Application no: **3/2021/0823**

Address: **Land off Sheepfold Crescent Barrow BB7 9XR**

Proposal: **Discharge of conditions 5 - Wildlife Highway Details 9 - Acoustic Fence Details 11- S278 for the offsite access with LCC 15 - Construction Method Statement and Site Layout**

DRAWING NUMBER
065/CMS/01

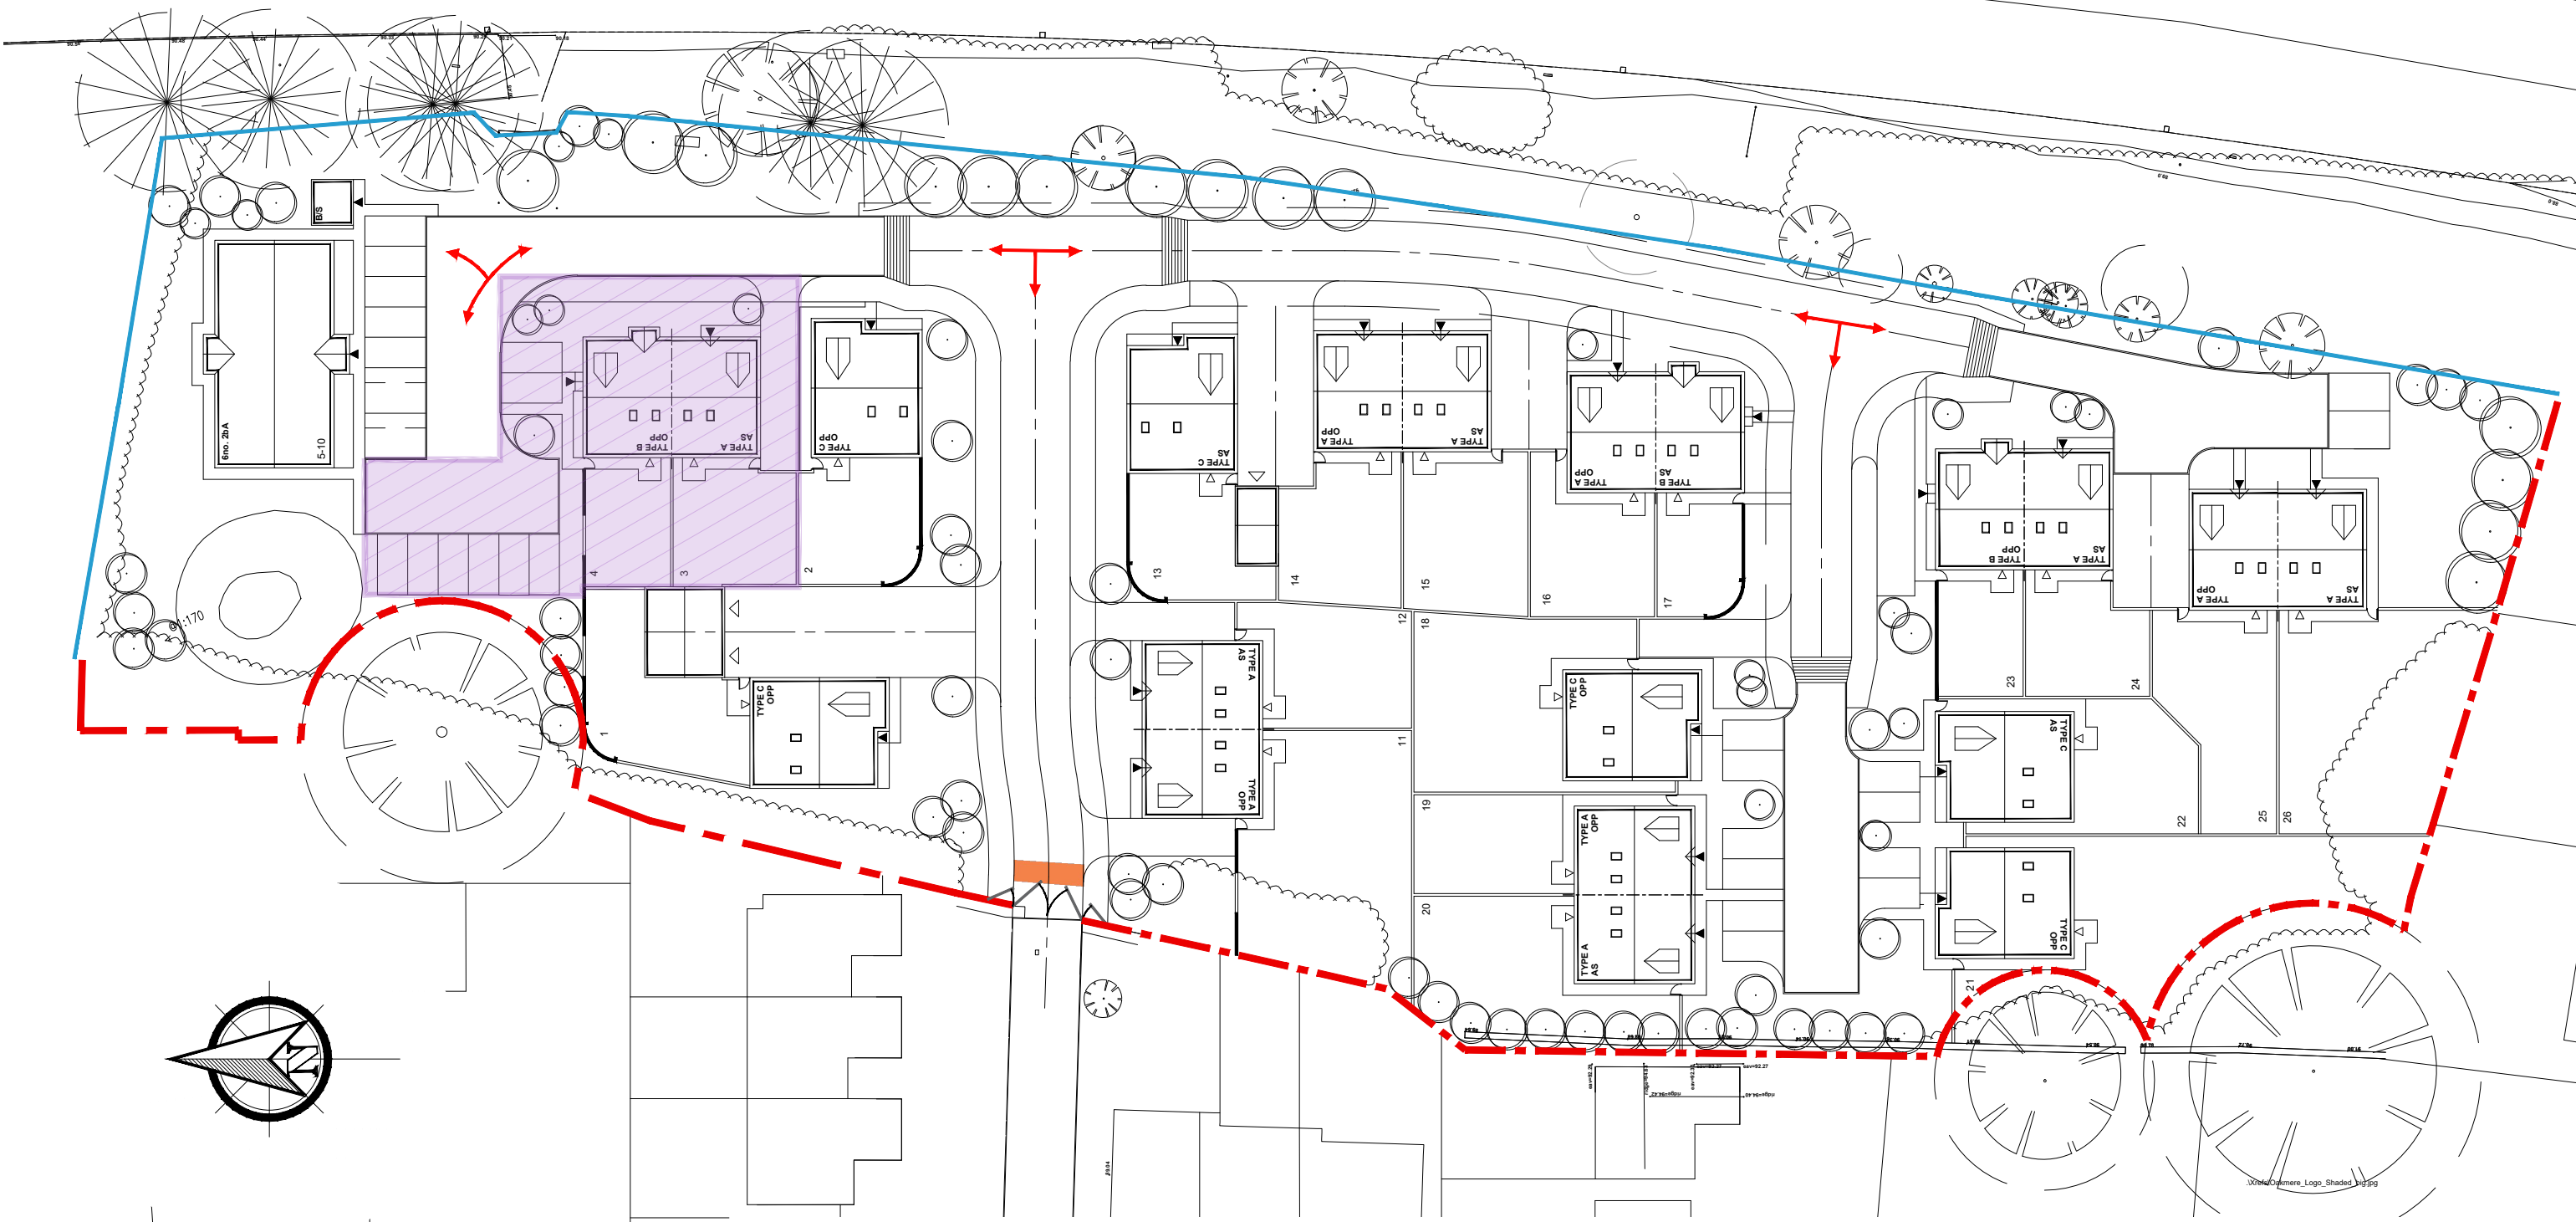
The LHA have reviewed 065/CMS/01 and the Traffic Management Strategy and are satisfied that the site complies with the LHAs guidance and so have no objection to the discharge of condition.
